North West Rail Link (NWRL)

Environmental Impact Statement 2

**Response Submission regarding detrimental
impact of NWRL on Robert Road**

**Andrew Harrington
11 Robert Road
Cherrybrook NSW 2126**

Figure 6.12 Cherrybrook Station - Indicative vehicle and pedestrian movements

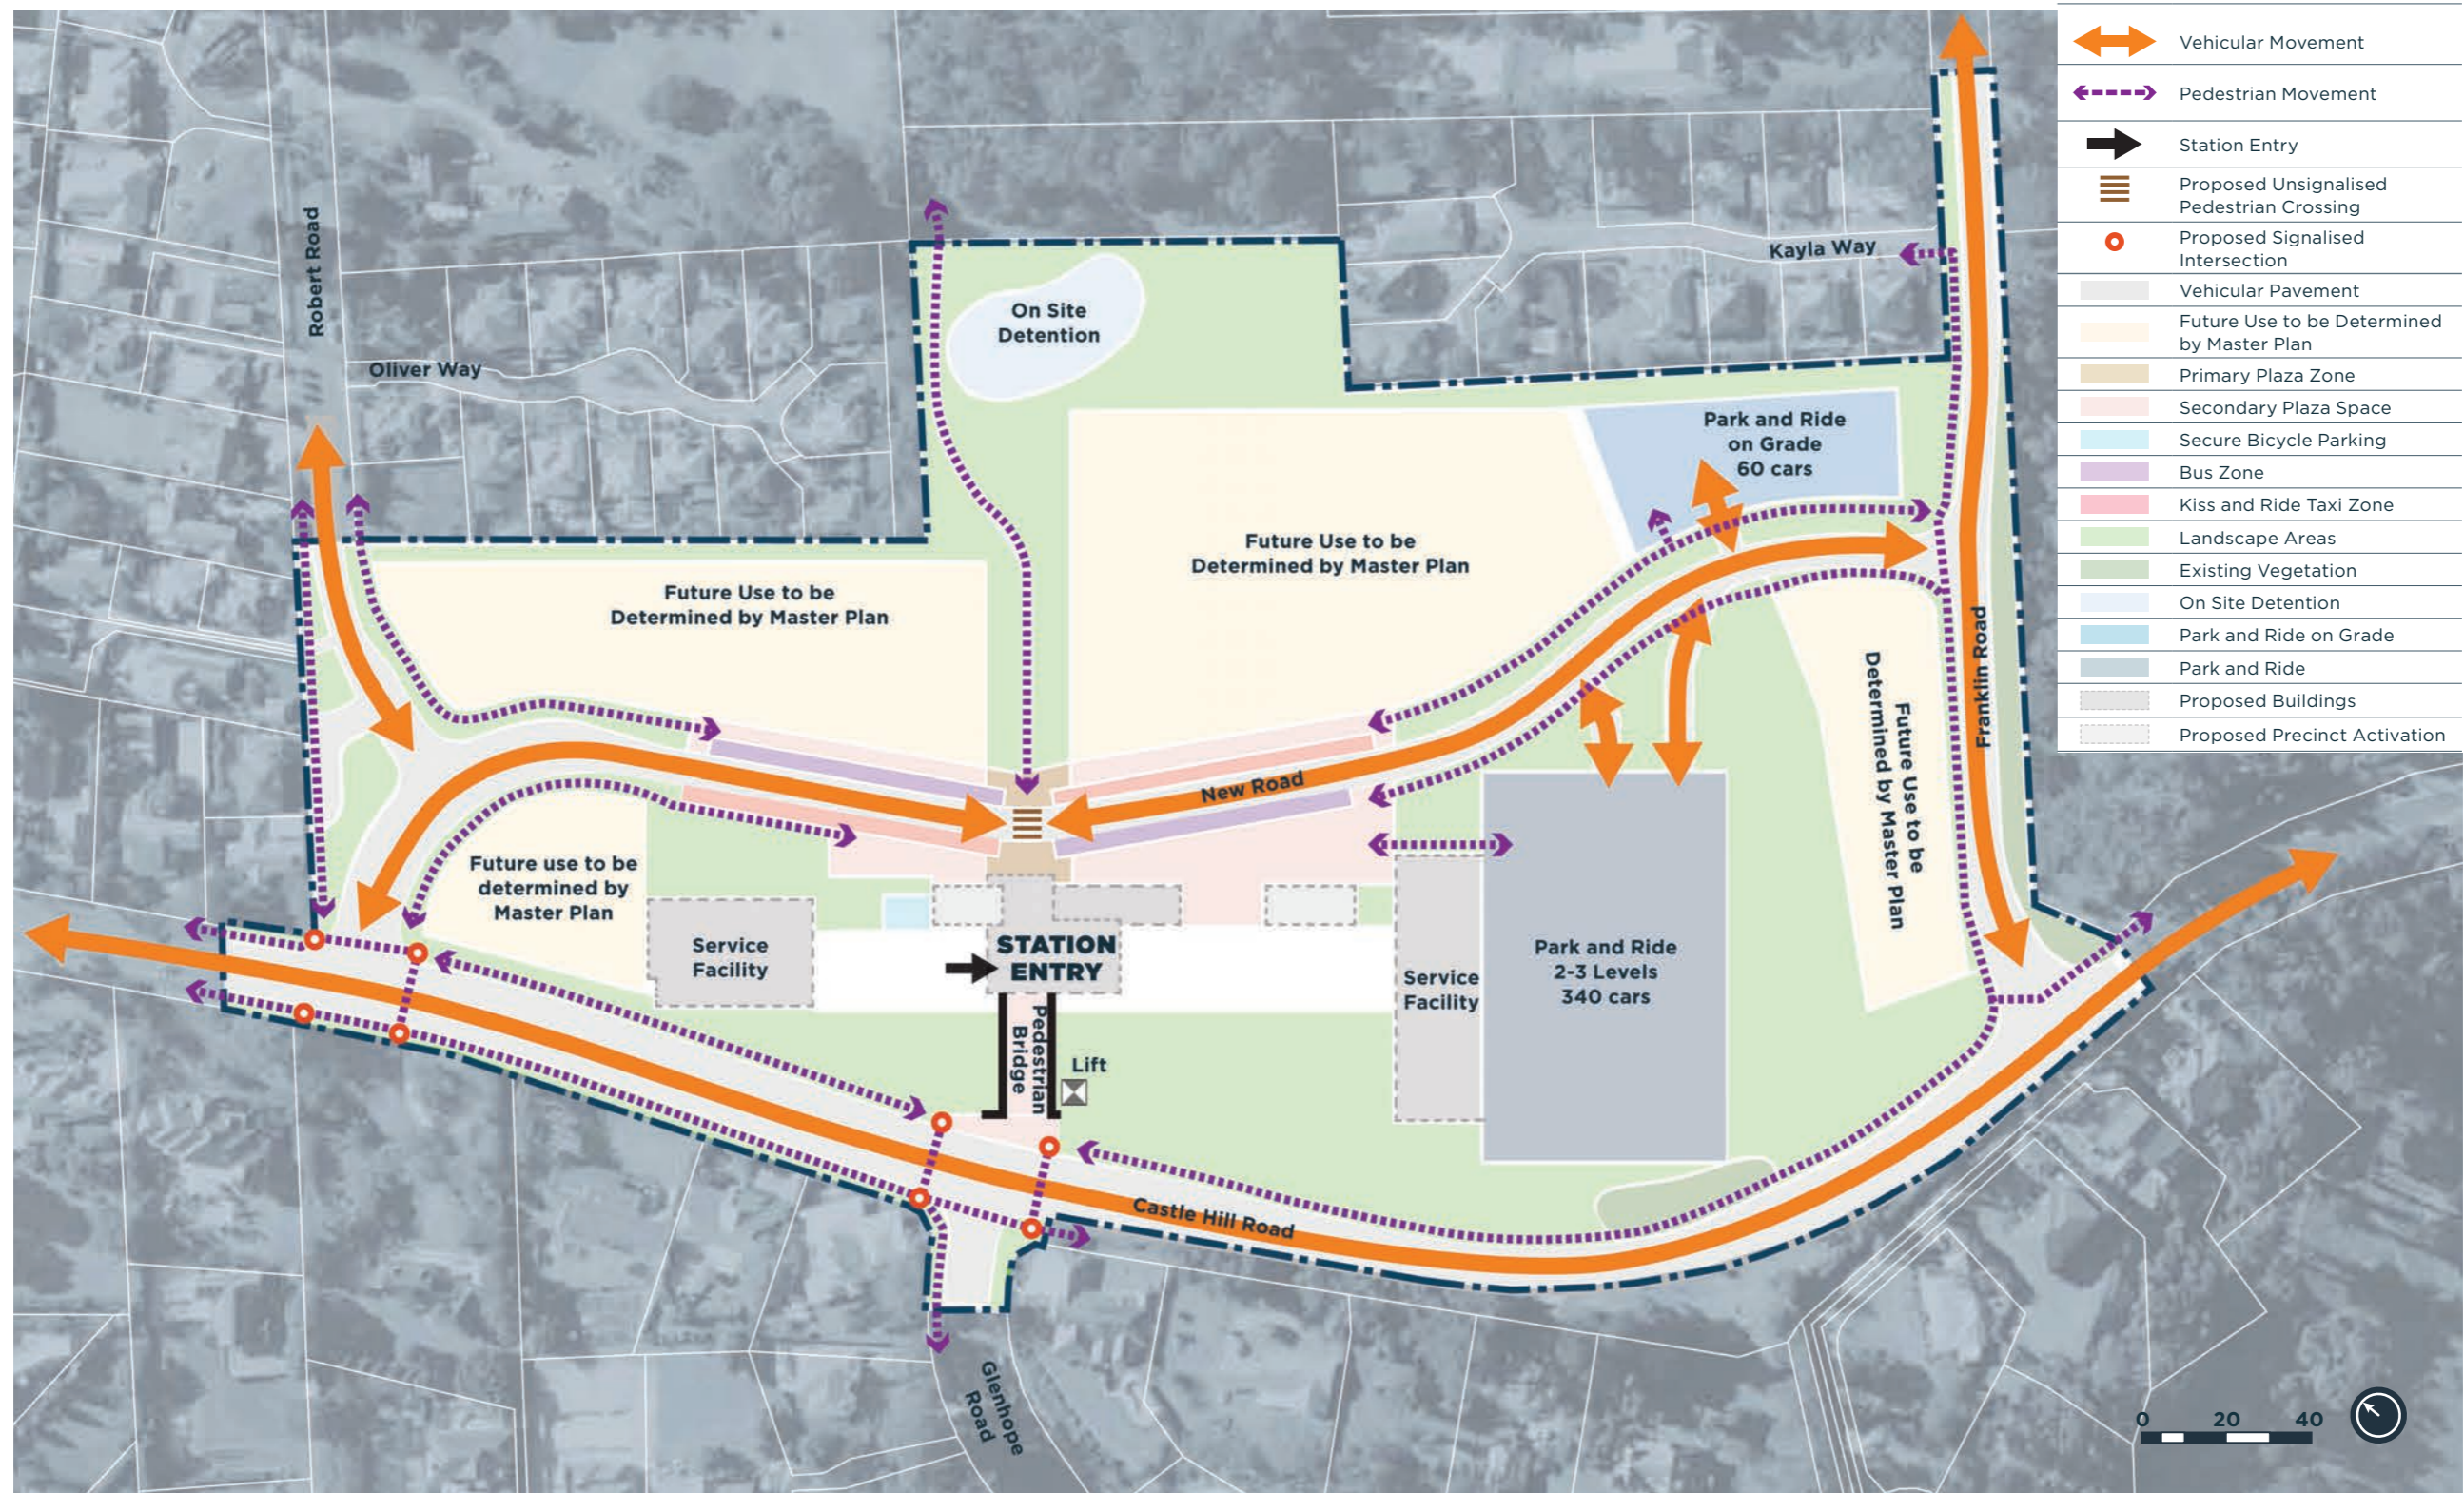
- a. The NWRL proposes to turn Robert Road into a major bus and car entry point to the Cherrybrook station, as per the following statement:

A key element of the station precinct is a new link road between Robert Road and Franklin Road. This will provide a 'front door' to the station and a high quality space for management of buses, kiss & ride and park & ride access, with commuter car parking spaces also accessed from the link road.

As residents we feel highly aggrieved about this, as it will significantly impact on the liveability of Robert Road, which is currently a quiet residential street. The decision to route northbound and southbound bus services along this street, which in parts is no wider than seven (7) metres across, will completely destroy the nature and fabric of the street that we know and love today.

Buses would approach and depart the station via Robert and Franklin Roads and access bus stops in the new station access road close to the station entrance. Buses would operate two-way in both Robert and Franklin Roads as far as John Road and Neale Avenue respectively. Parking would need to be banned from both sides of both Robert and Franklin Roads to allow for safe bus operation.

The removal of parking on Robert Road would be very unfavourable to the battle-axe blocks and community estates adjoining Robert Road, which have limited off street parking. Street parking is imperative throughout Robert Road given the sheer quantity of houses in these developments, where in the absence of sufficient off street parking, residents and their guests are required to park in the street.

Widening of Robert Road from 7.5 metres to about 14 metres between Castle Hill Road and the station access road to provide two traffic lanes in both directions.

Apart from resulting in a deterioration of the quality of life of the residents of Robert Road, many of whom represent an older generation, this proposal will also eat into properties and in some cases impact on the historical nature of homes.
